Great North Road Solar and Biodiversity Park

Environmental Statement

Technical Appendix A7.1 – Consultation

Document reference – EN010162/APP/6.4.7.1

**Visual Receptors -
Scale of Change After Mitigation
Figure 7.7**

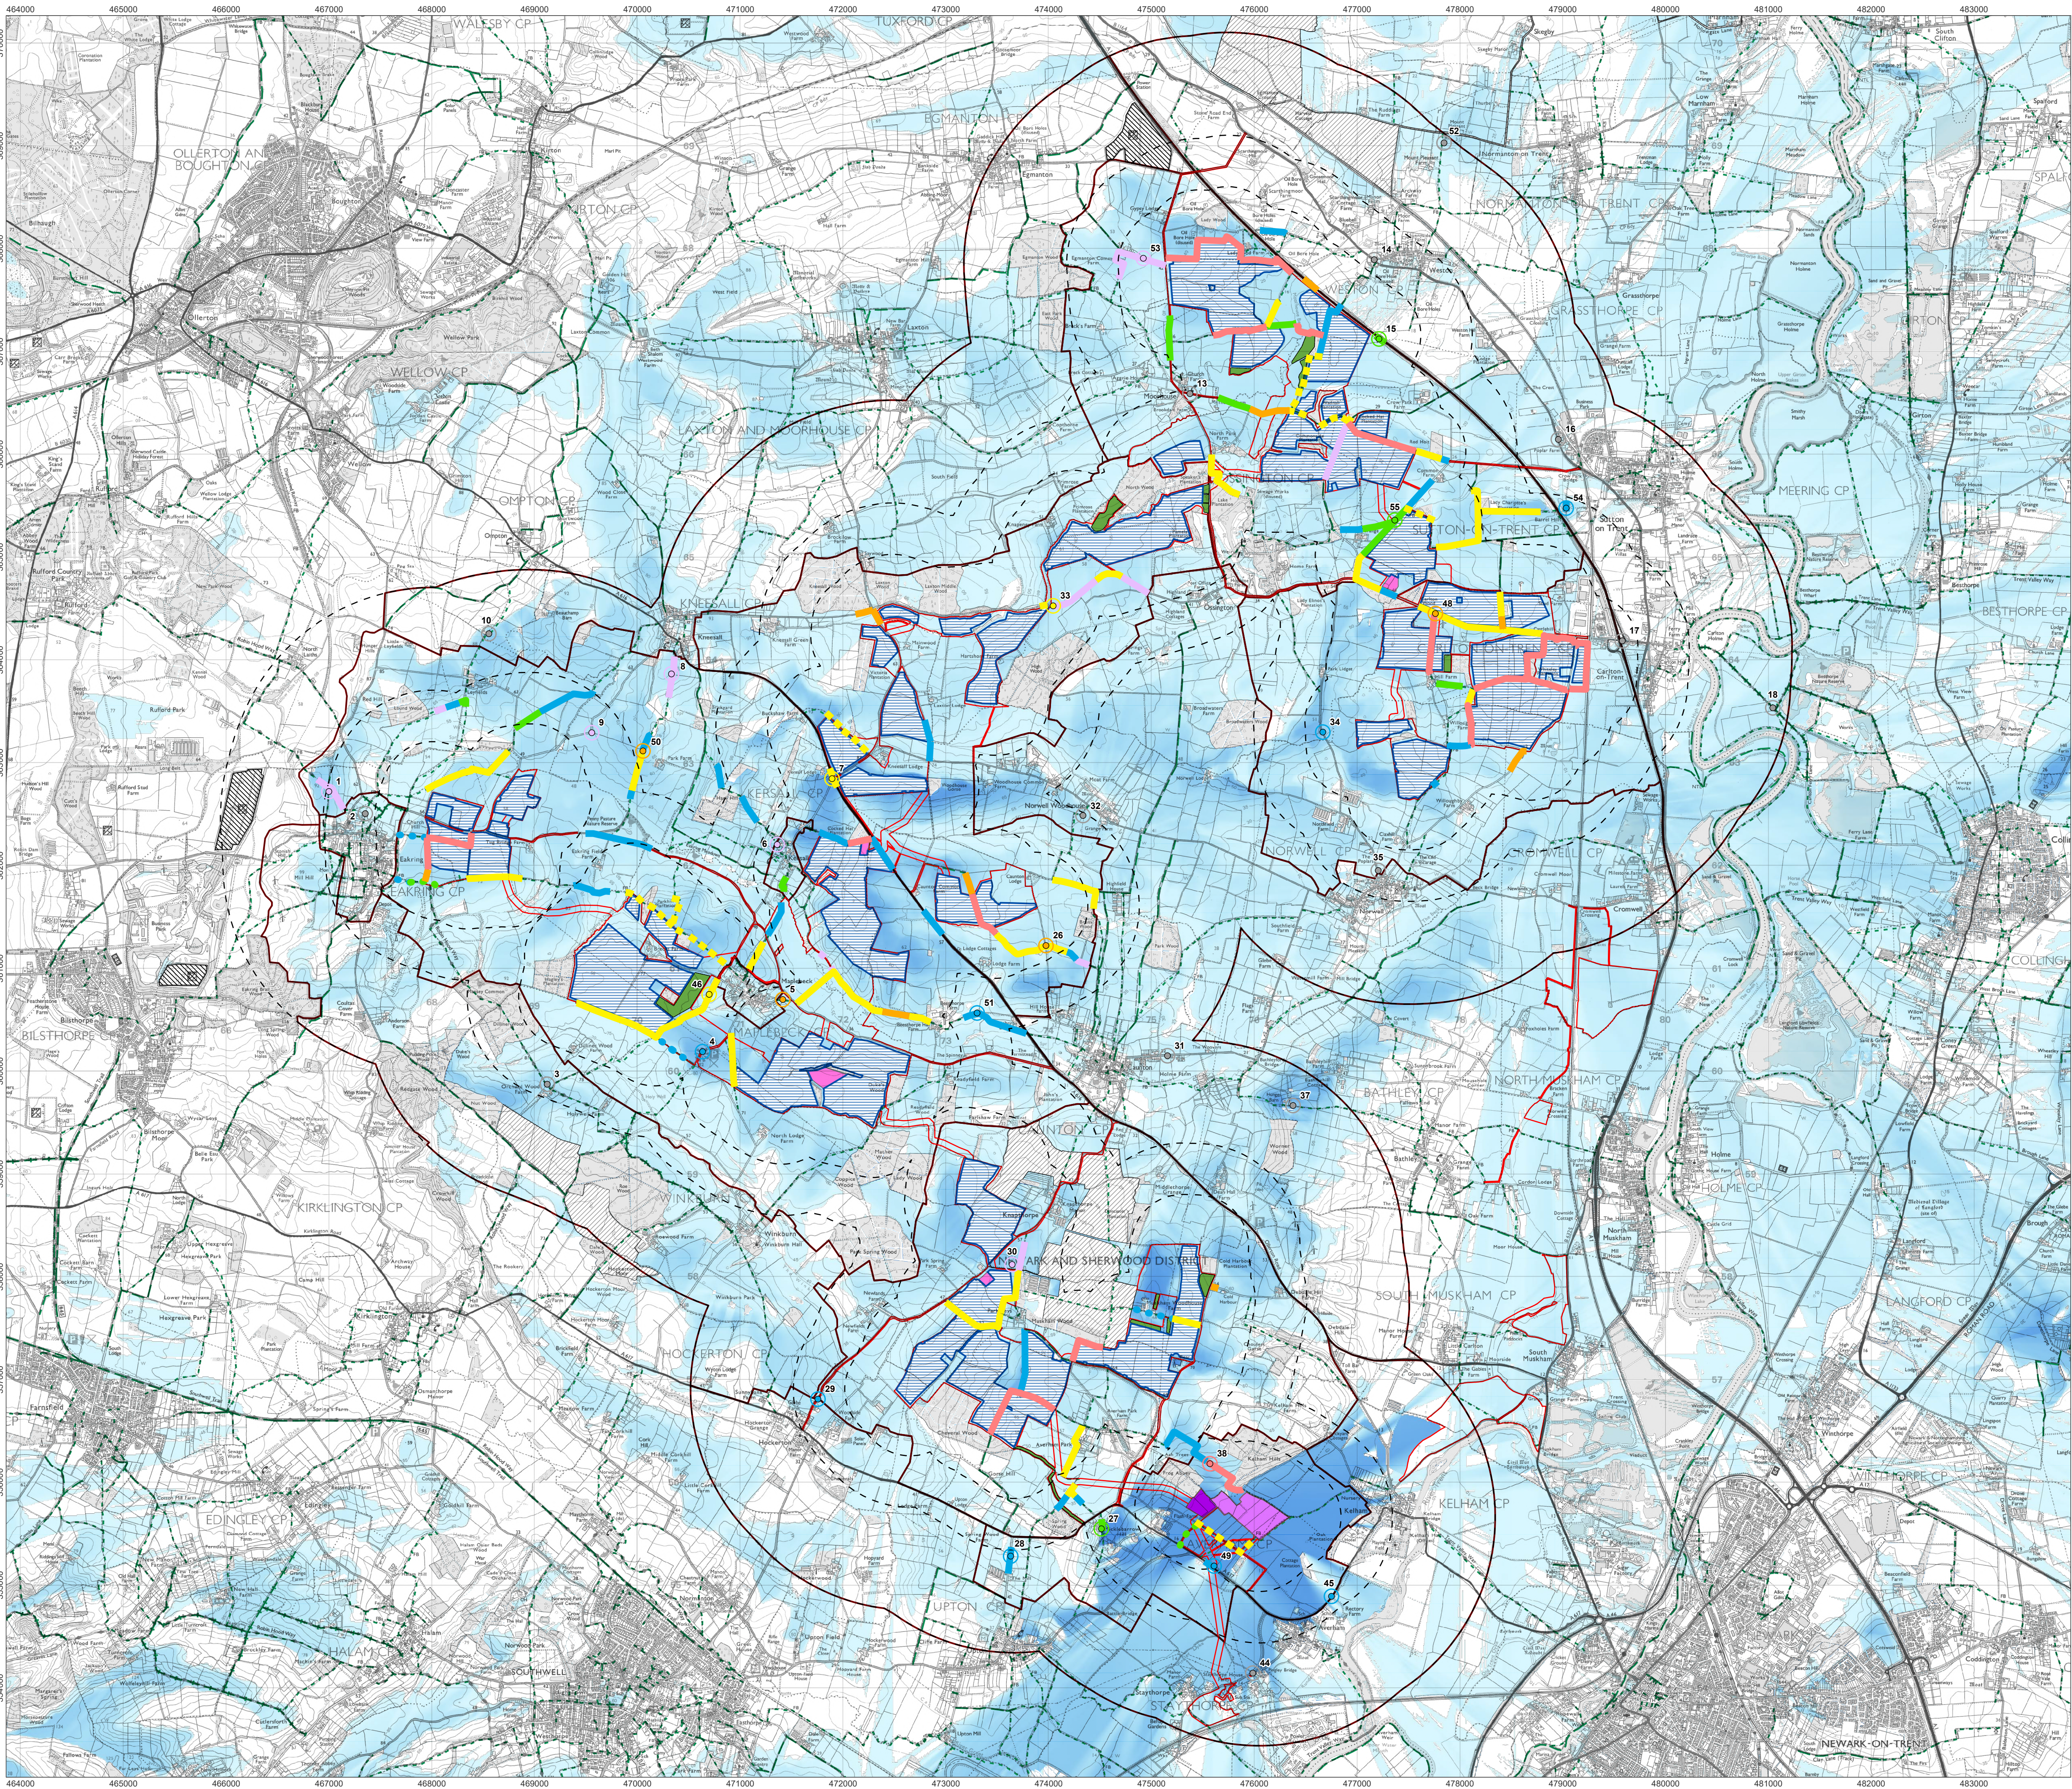
Ref	Issue	How this is addressed
Figures		
PINS 2.2.10	It would be helpful if each chapter of the ES provided figures showing the location of all receptors or groups of receptors considered.	Landscape and visual receptors are shown on Figures 7.3 to 7.7 [EN010162/APP/6.3.7.3-7].
PINS 2.2.11	All figures should include the Order Limits.	It is considered that the Order Limits are of limited relevance to the extent and significance of landscape and visual effects given that it will not be a tangible feature in the landscape; and it can obscure and distract from the information that is important – particularly given the complex shape of the Order Limits for this project. However, it is included on Figures 7.3 (Landscape Character) [EN010162/APP/6.3.7.3] and 7.5 (Visual Receptors) [EN010162/APP/6.3.7.5] as requested.
PINS 2.2.12	It would be helpful to provide figures in a searchable format rather than as images.	Searchable figures have been provided where this does not cause file sizes to exceed the upload limit.
